Ribchester Parish Council

PLANNING APPLICATION No: 3/11/0999

Application: Proposed rear single storey extension to include kitchen, utility and WC

At: 9 Ribblesdale Road, Ribchester

TITLE Existing +
Proposed

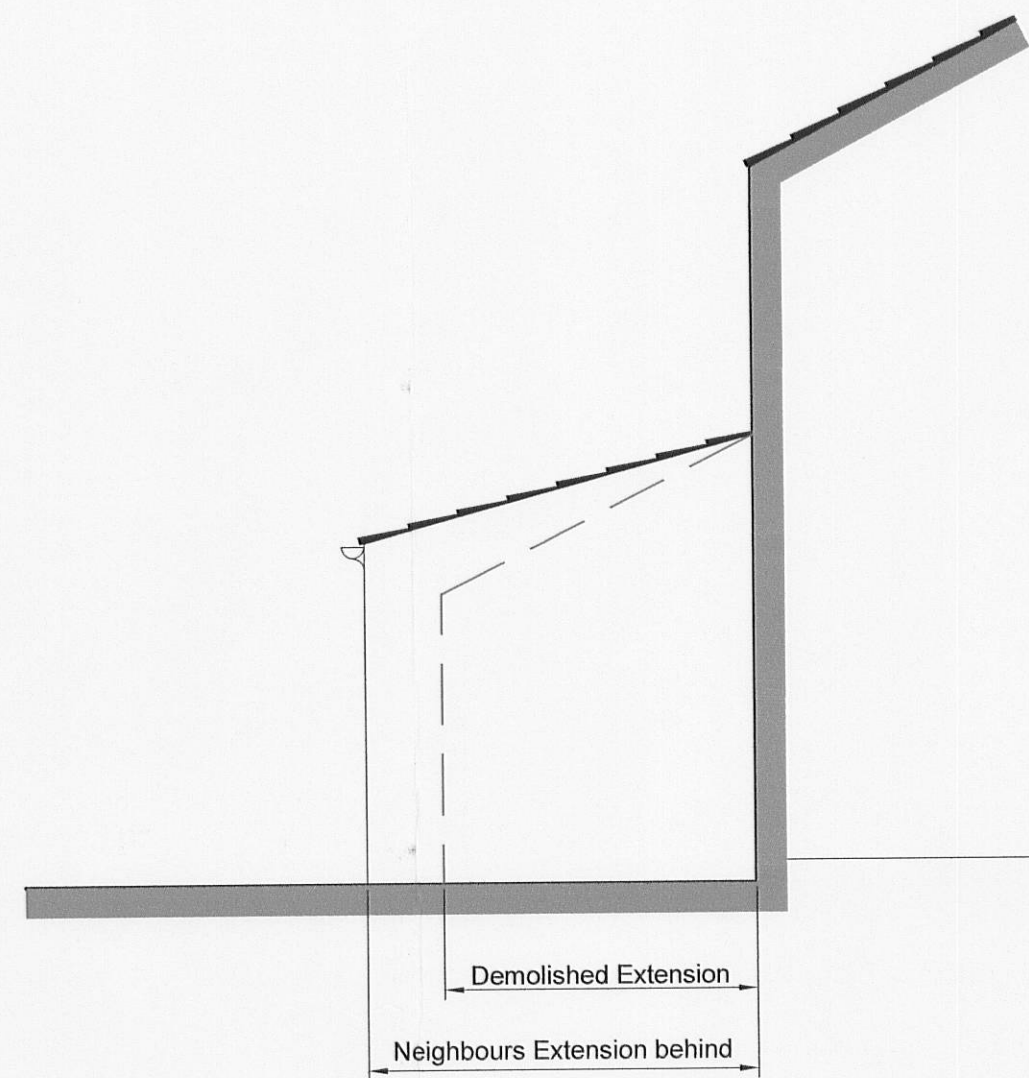
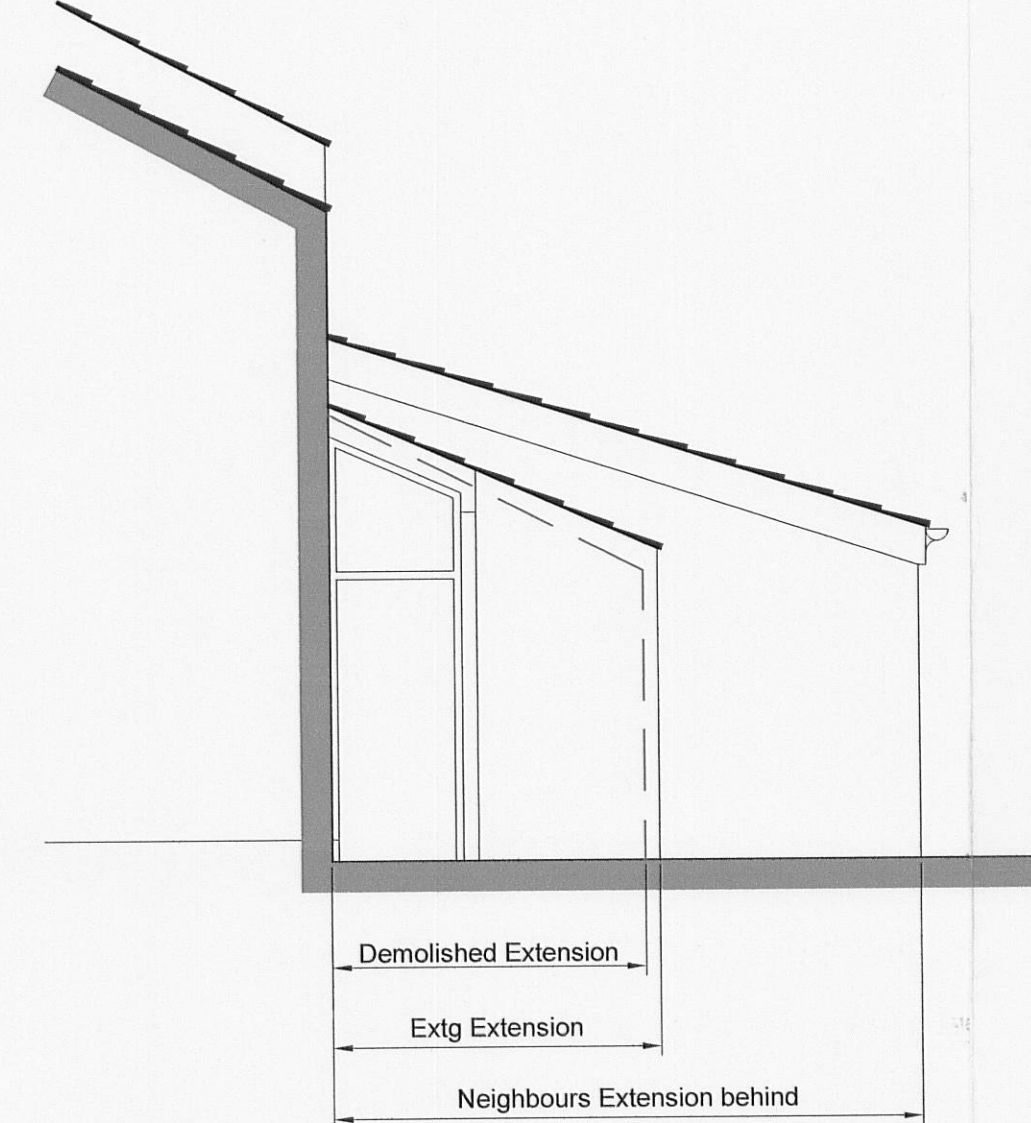
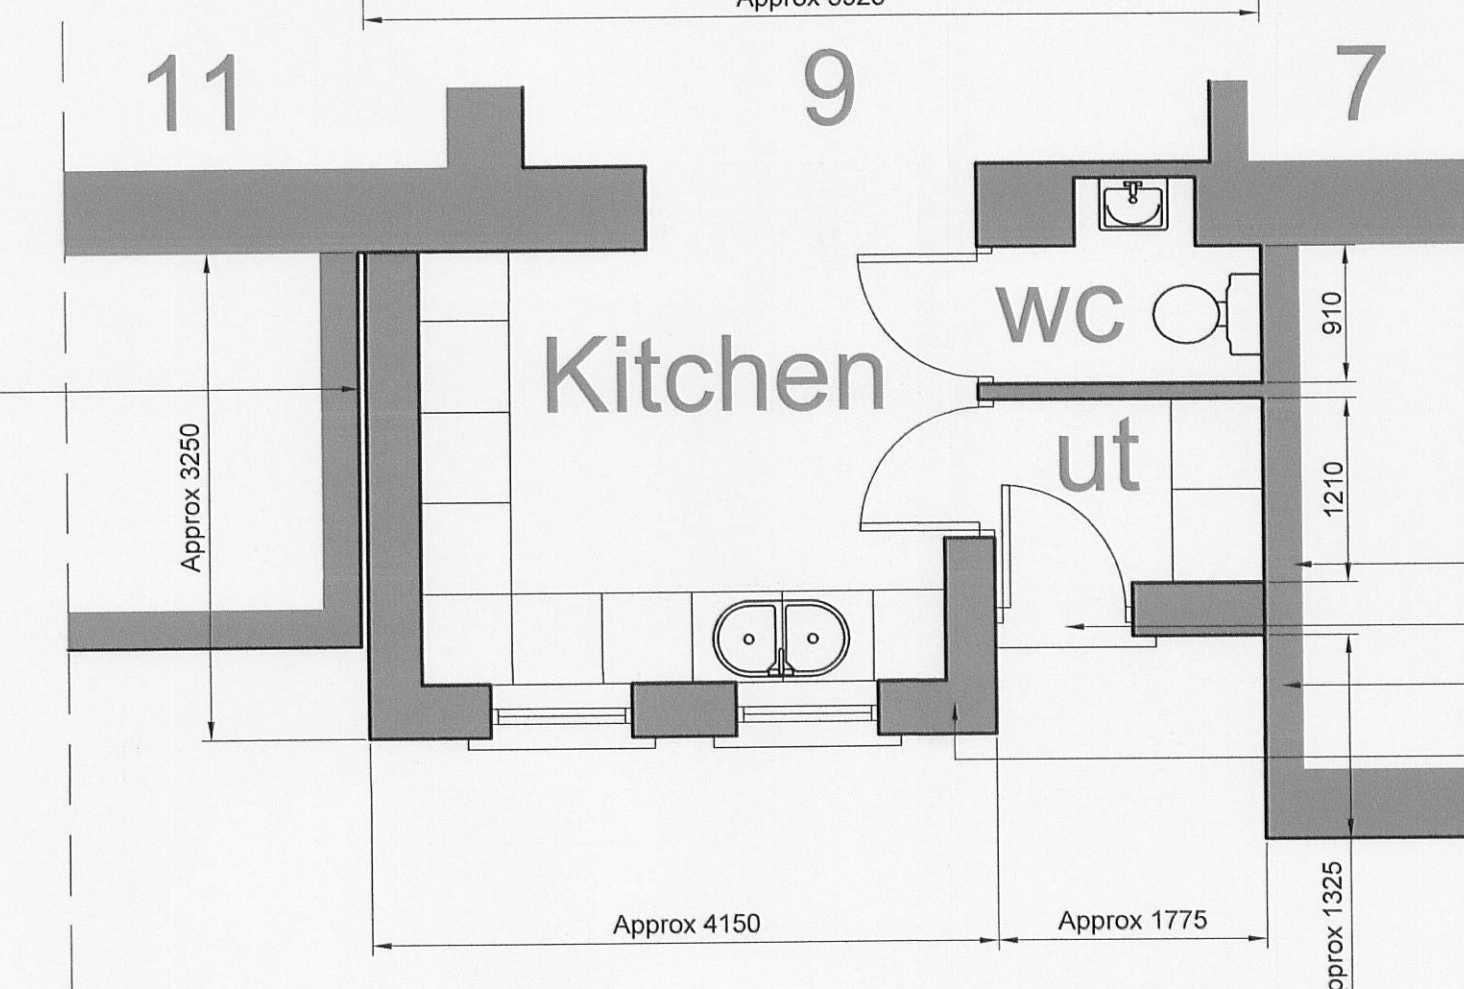
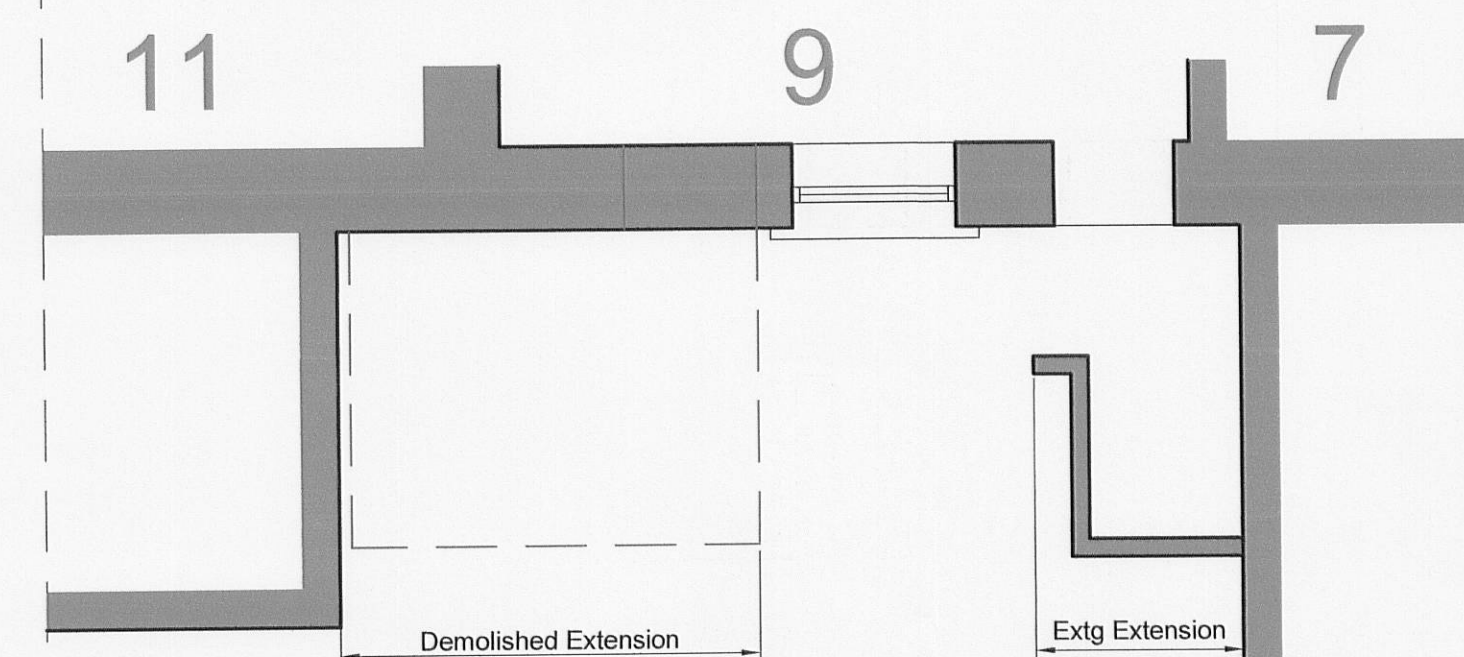
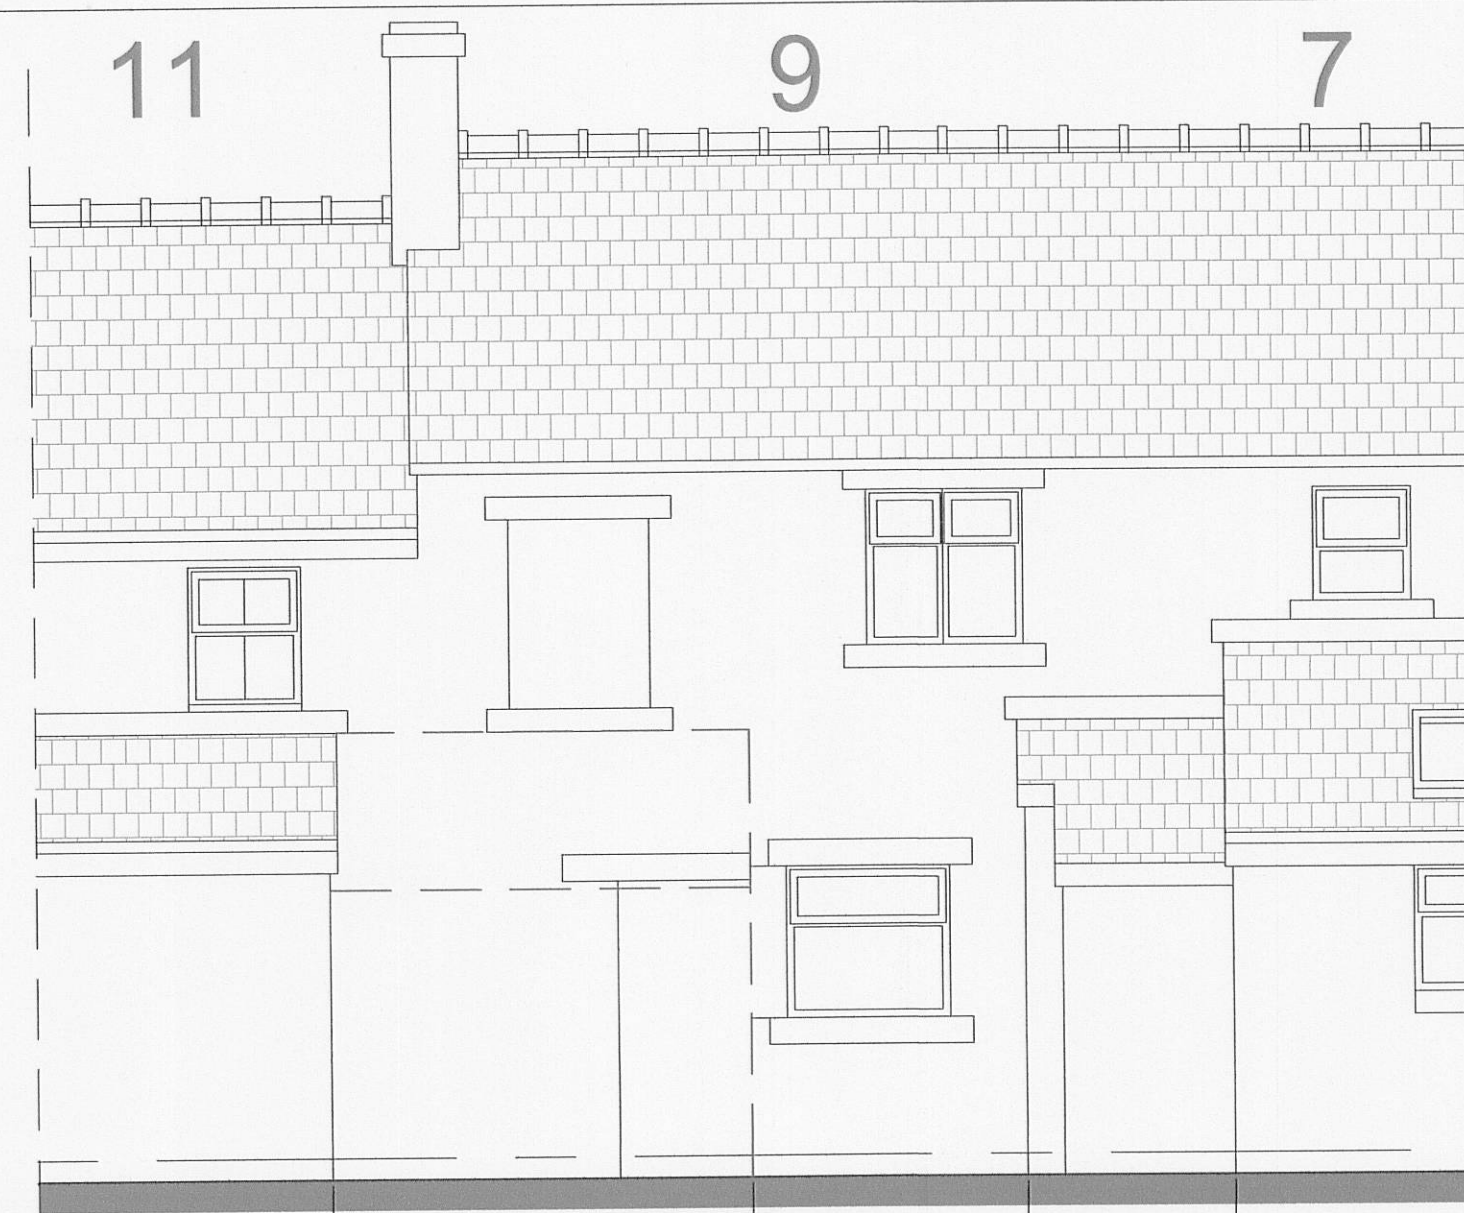
The appraisal document goes on to say that where possible the original doors and windows should be retained or, if this is not possible, any replacement should copy the original in materials, design detail and paint finish. With this in mind the Council points out a contradiction in the documents submitted with the application:

On page 3 of the application is a statement that it is proposed to replace doors and windows with UPVC, while at para 1.13 of the design statement the proposal is for replacement in wood.

In the spirit of the Appraisal document The Council would prefer a 'like for like' replacement.
